Regulatory, Planning and Assessment.MBisson/GMansfield  
Reference: PB2021/07290, SDC2021/0013  
Phone: 02 4974 2000

## **M1 PACIFIC MOTORWAY EXTENSION TO RAYMOND TERRACE (SSI-7319)**

I refer to your email dated 28 July 2021 advising City of Newcastle ('CN') of a State significant infrastructure development (SSI-7319) submitted by Transport for NSW (TfNSW) for the above project and seeking CN's comments.

The submitted Environmental Impact Statement (EIS) has been reviewed and the following advice is offered for your consideration:

Figure 5-13 Existing and proposed cycle route (map 2 of 5)

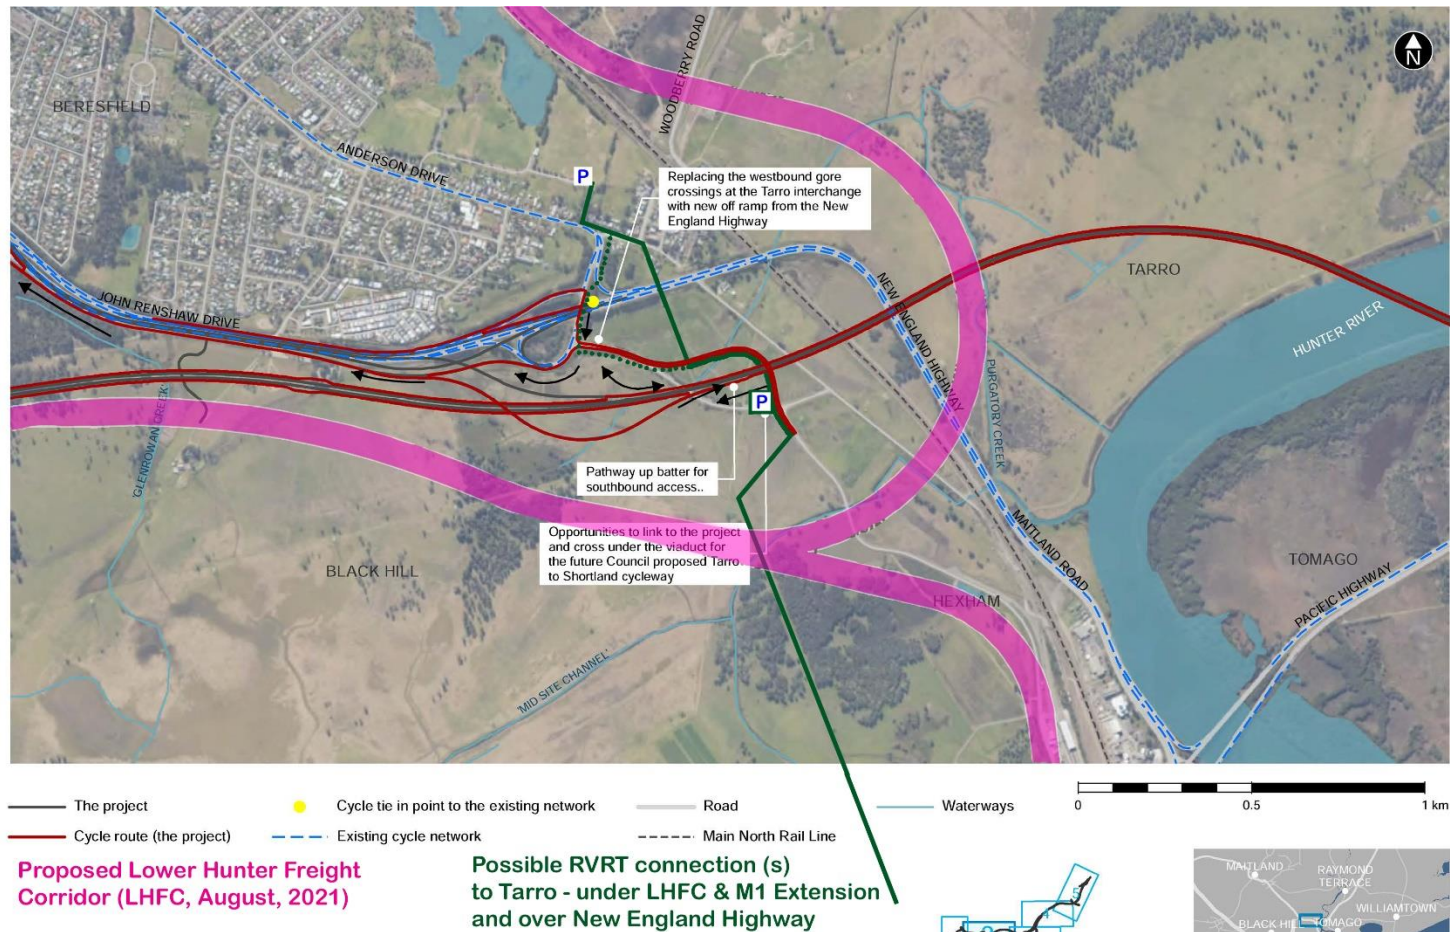
- A simpler option would be to align the future Tarro to Shortland cycleway to the north-eastern side of the realigned Aurizon Access Road separate from the road between the next set of piers for the M12RT viaduct.
- TfNSW is proposing a cycleway connection to the M12RT from the realigned Aurizon Access Road for cyclists to travel south along the road shoulders of the new M12RT. A similar cycleway connection would be provided for northbound cyclists from the existing Tarro interchange to travel north along the road shoulders of the new M12RT. The future Shortland to Tarro cycleway would be able to connect to these cycleway connections to the M12RT.
- TfNSW would continue to liaise with CN on the design in this area to ensure the future Shortland to Tarro cycleway can be provided for (e.g. extension of drainage culvert at Purgatory Creek to allow for simpler construction in future).

- Diversion of the cycleway from the main pipeline corridor to Pipeline Road;
- Crossing of the Aurizon Access Road in the vicinity of the proposed connection from M12RT to Aurizon Access Road;
- Shared path cycleway to pass under the M12RT elevated section on east side of Aurizon Access Road;
- The cycleway to generally follow the Aurizon Access Road (on east and north side) alignment with clear separation between the road and cycleway until re-joining the pipeline corridor;
- TfNSW extend the culvert over Purgatory Creek (as per M12RT project) to allow for future cycleway construction (nominally extension by two lengths, 4.8 metres);
- The cycleway to continue north on pipeline alignment and cross under the New England Highway in existing Hunter Water culvert.

- Lengthen the culvert over Purgatory Creek by two lengths minimum;
- Align the Aurizon Access Road to allow the cycleway to pass under the M12RT on the east side of the diverted road.
